**Summary of oral case from Issue Specific Hearing 15 & 16 September
2015
For
The Royal Society for the Protection of Birds**

Hornsea Offshore Wind Farm – Project Two

**Planning Inspectorate Ref: EN010053
Registration Identification Ref: 10031166**

Summary of the RSPB's oral case from the Issue Specific Hearings on 15-16 September 2015

**Figure 1. Proportions of kittiwakes recorded at Potential Collision Height (PCH) (as % of all kittiwakes recorded at the site)**

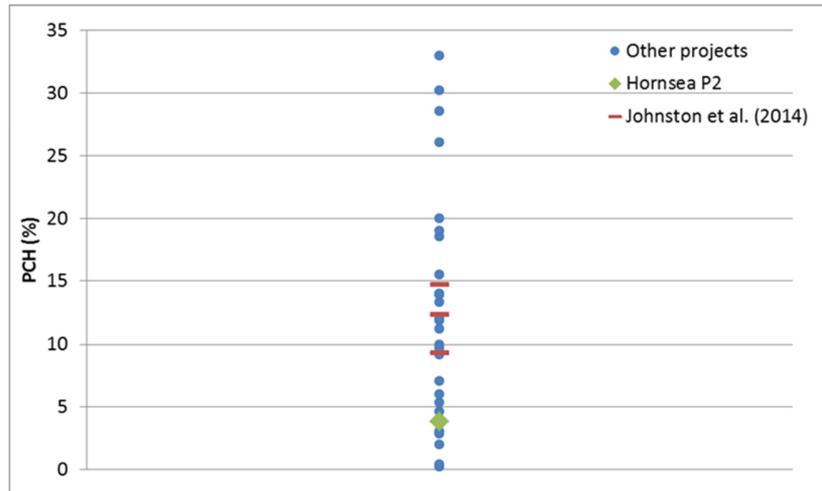
- c. For a number of species, the proportion of flights estimated to be at PCH (potential collision height) at Hornsea Project Two, is substantially lower than those in Johnston *et al.*, (2014). For kittiwake, lesser and great black-backed gulls in particular this proportion was lower than the lowest 95% confidence intervals for the generic data and for kittiwake this was lower than that of any other offshore development. These figures for flight height of kittiwake at Hornsea Project Two are also considerably lower than those obtained from elsewhere by different means of estimating flight height. This disparity leads to concern that assessment based on site-specific data presented by Hornsea Project Two may lead to underestimation of the risk of collision, notably for kittiwake. The magnitude of this observed difference merits critical examination. Such a critical examination has not been presented for Hornsea Project Two; rather there is the statement that standard methods were used by experienced surveyors. There are three possible explanations:

- i. While we would not question the experience of the surveyors, the method used to determine flight height for Hornsea Project Two was the *estimation* of height to the nearest 5 metres (HRA, Annex 5.5.1, para 2.1.7 pg 4: *the estimated height of flying birds was recorded to the nearest 5m*”). This is contrary to standard practice which is that birds are apportioned to height bands, often with reference to fixed structures. This methodological

difference is the most likely explanation for the discrepancy in flight heights. Research by the Marine renewable Ornithology Group (comprising NE, SNH, NRW, NIEA, JNCC, RSPB and MSS) is ongoing into the accuracy of height estimation by boat based surveyors, but initial results suggest that estimation into 5m bands underestimates height to a greater degree than into broader bands.
